DRB Application No.: <u>04DRB-01183 (P&F)</u>	Project # <u>1003416</u>
Project Name: <u>TOWN OF ATRISCO GR UNIT 3</u>	
Agent: <u>Surveys Southwest</u>	Phone No.: <u>998-0303</u>

**CITY OF ALBUQUERQUE
PLANNING DEPARTMENT
August 11, 2004
DRB Comments**

RE: Tract 317-A, Town of Atrisco Grant, Unit 3/minor plat

**CITY OF ALBUQUERQUE
PLANNING DEPARTMENT
Development Review Board
May 12, 2004 Comments**

**SKETCH PLAT**  
**TRACT 317-A-1 & 317-A-2**  
**TOWN OF ATRISCO GRANT, UNIT 3**  
**PROJECTED SECTION 26, T. 10 N., R. 2 E., N.M.P.M.**  
**CITY OF ALBUQUERQUE**  
**BERNALILLO COUNTY, NEW MEXICO**  
**MAY 2004**

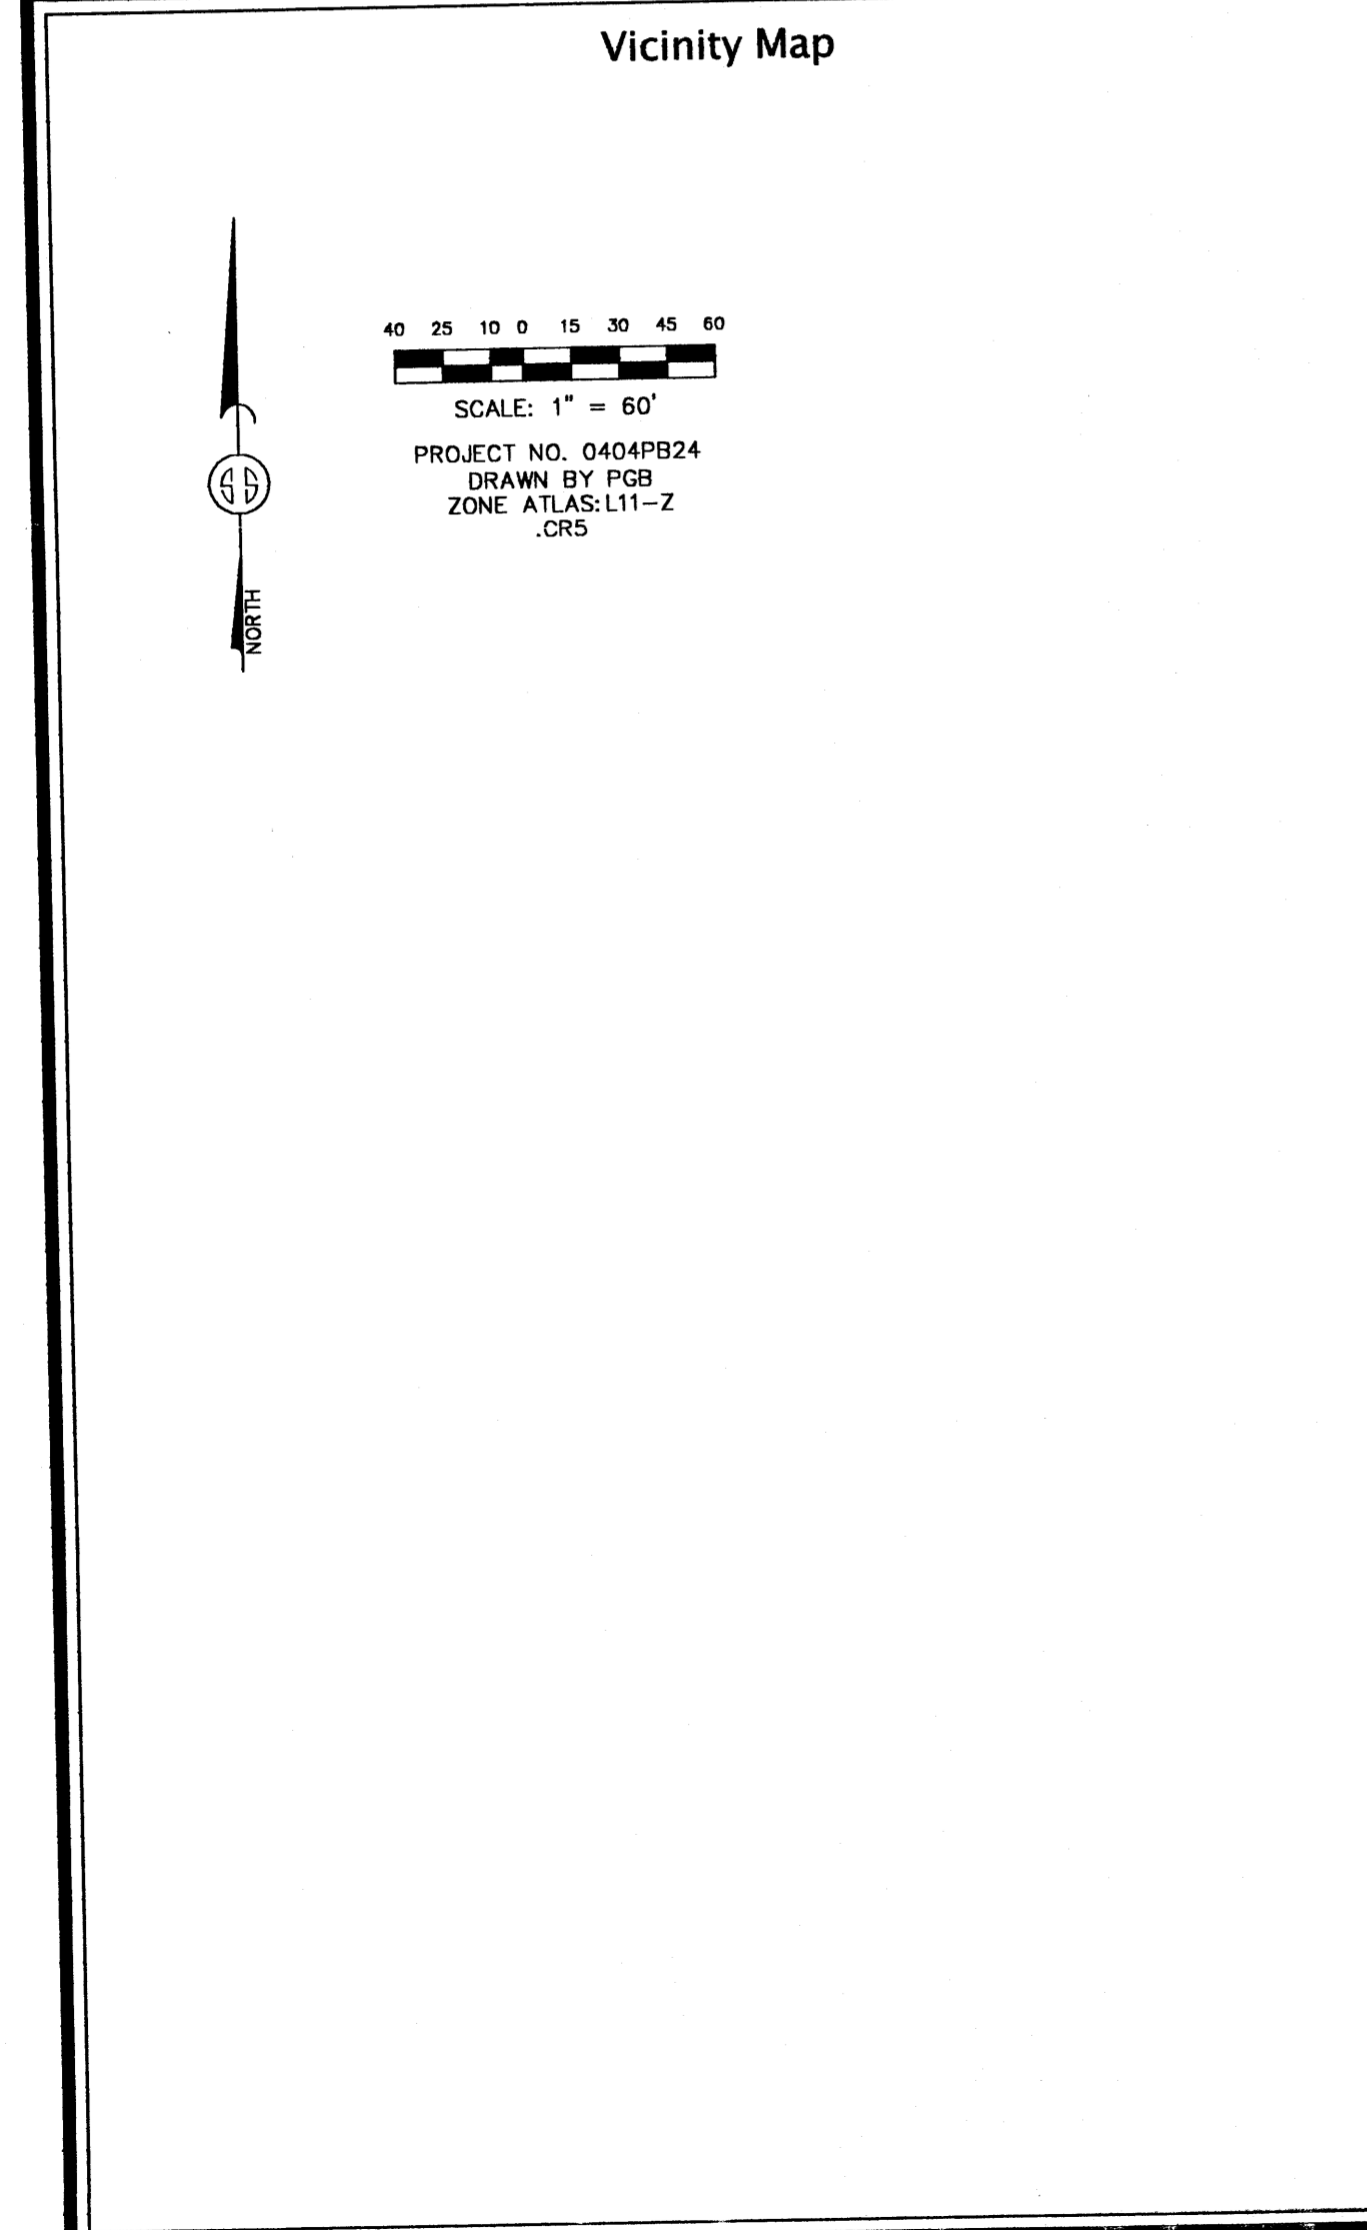
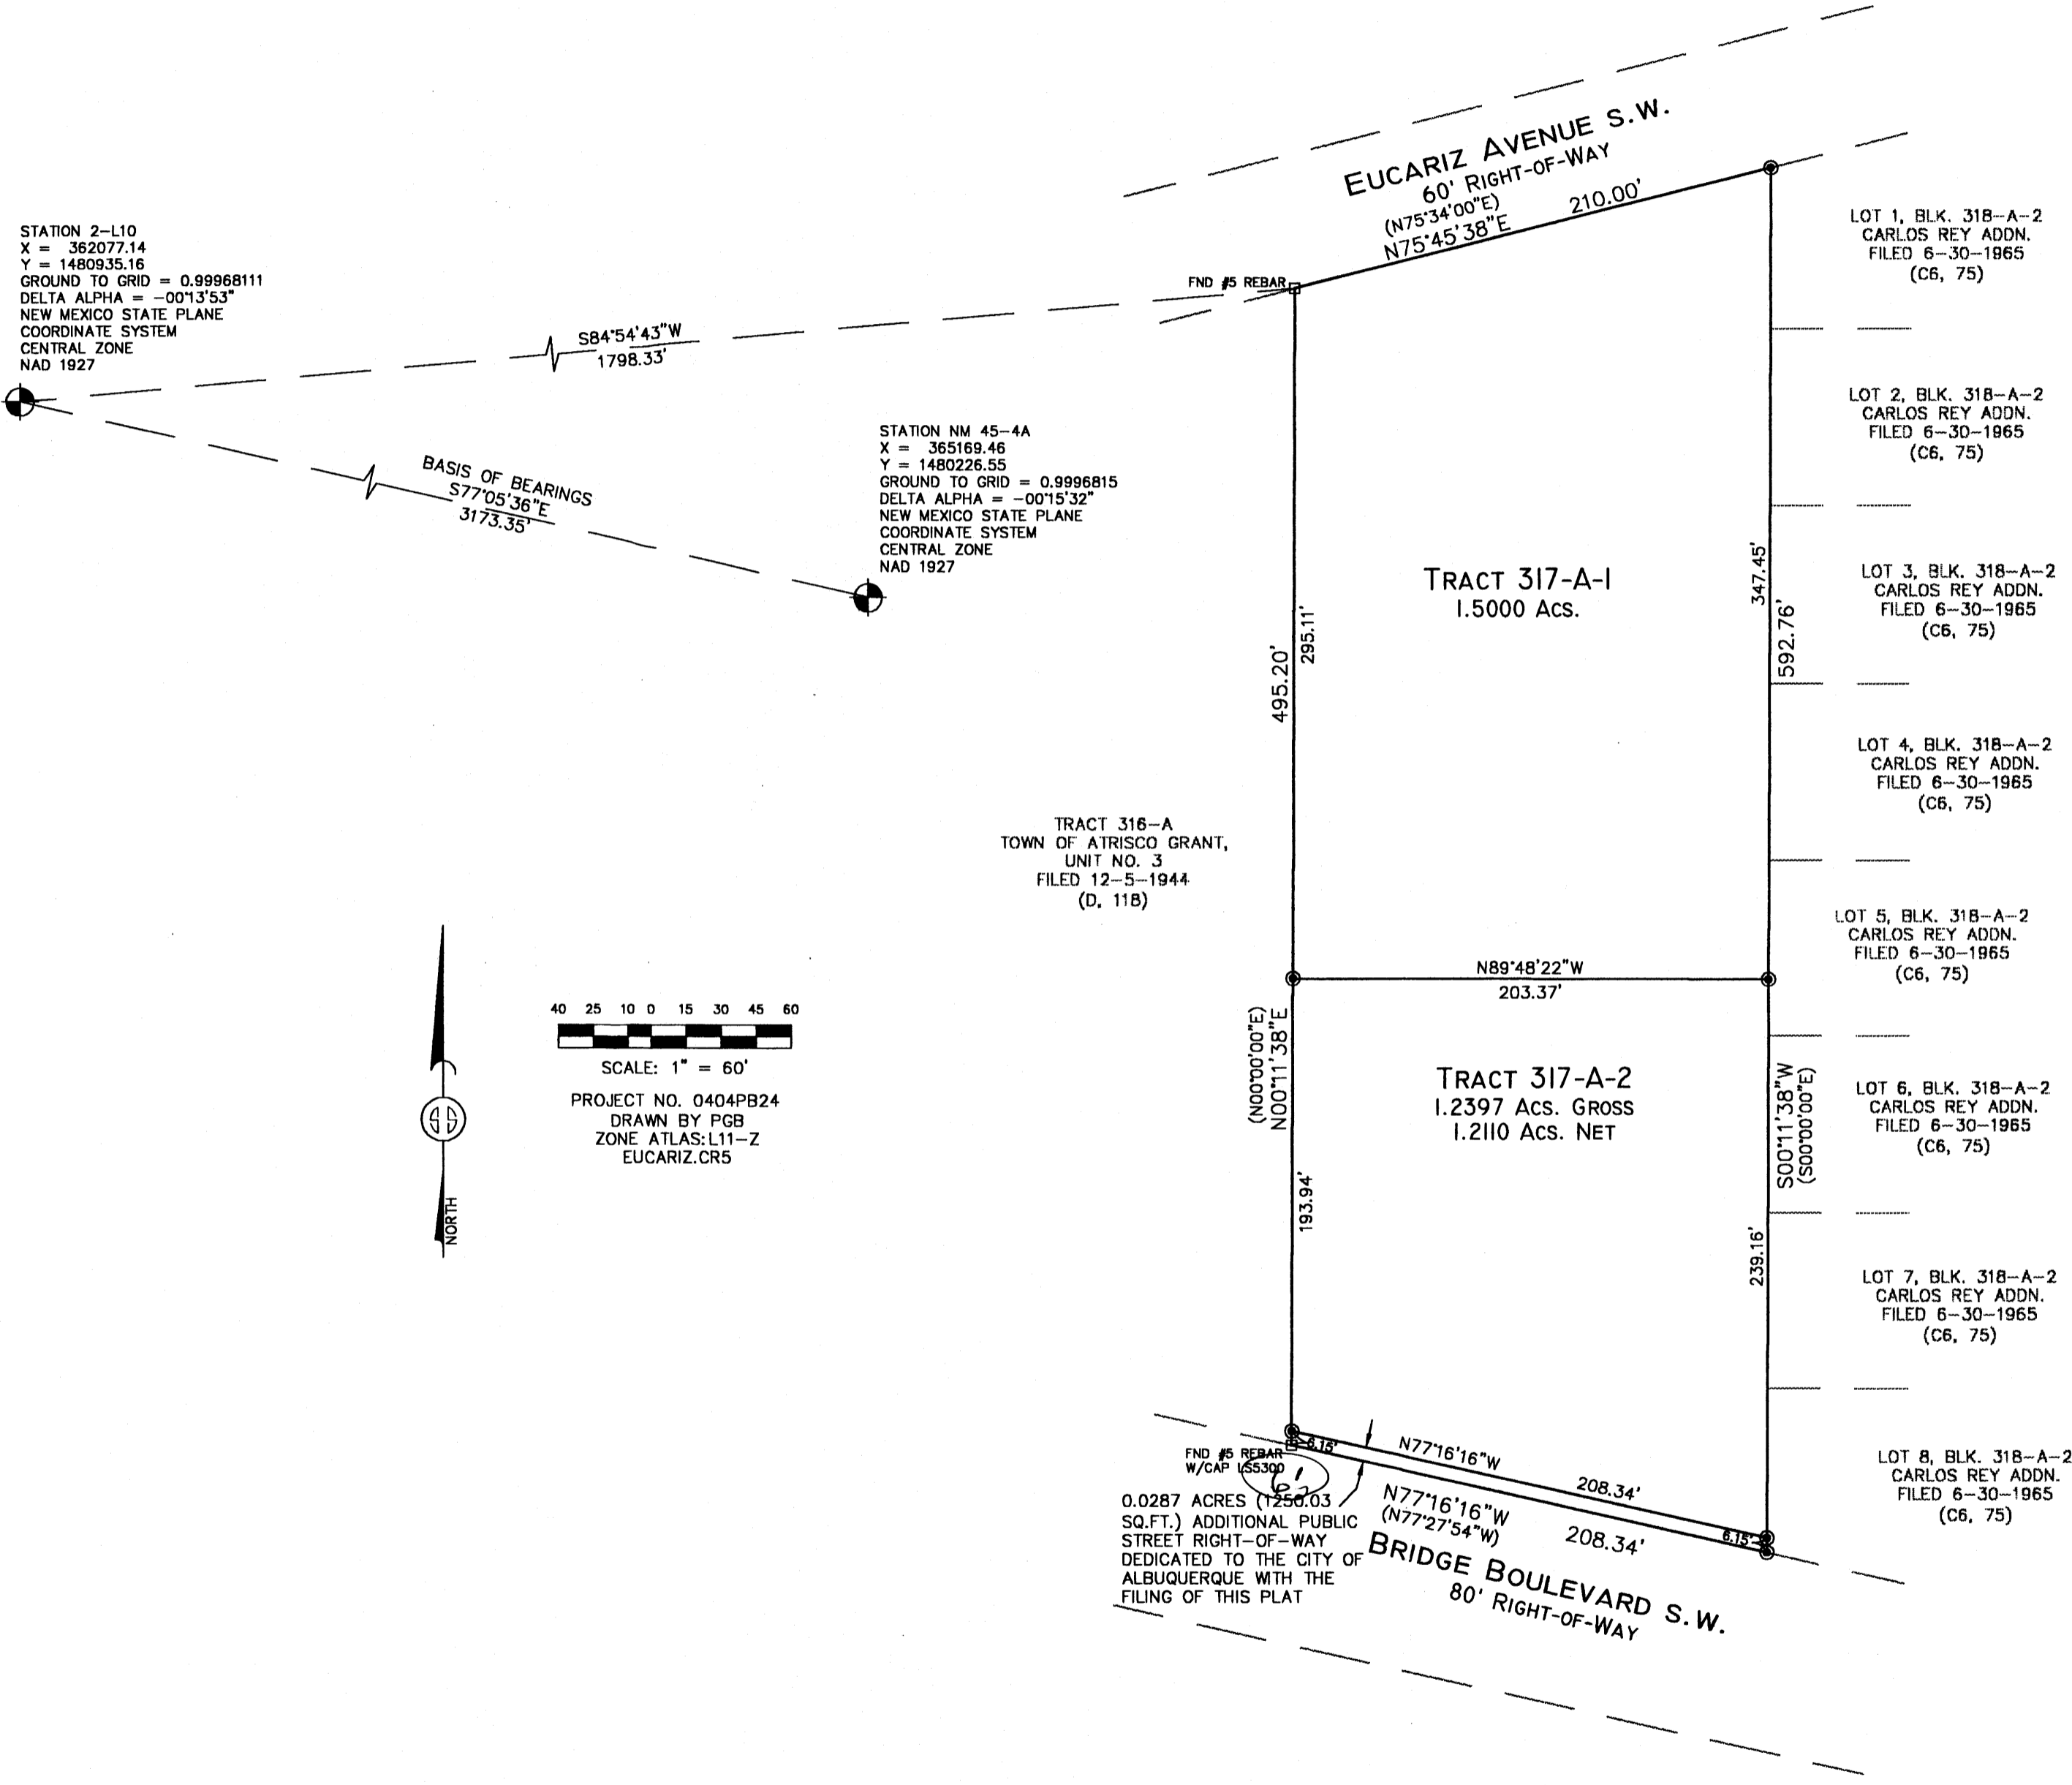
- 1) Bridge Boulevard may require 9' dedication. (bikelanes)
- 2) Need x-section of Bridge and Eucariz. (6' sidewalk)
- 3) Infrastructure needed for both Bridge and Eucariz.
- 4)

1. Sanitary sewer service is available in both frontages, therefore existing residence must connect to sewer service prior to final plat approval.

2. Public water service and fire protection is not available on Bridge.
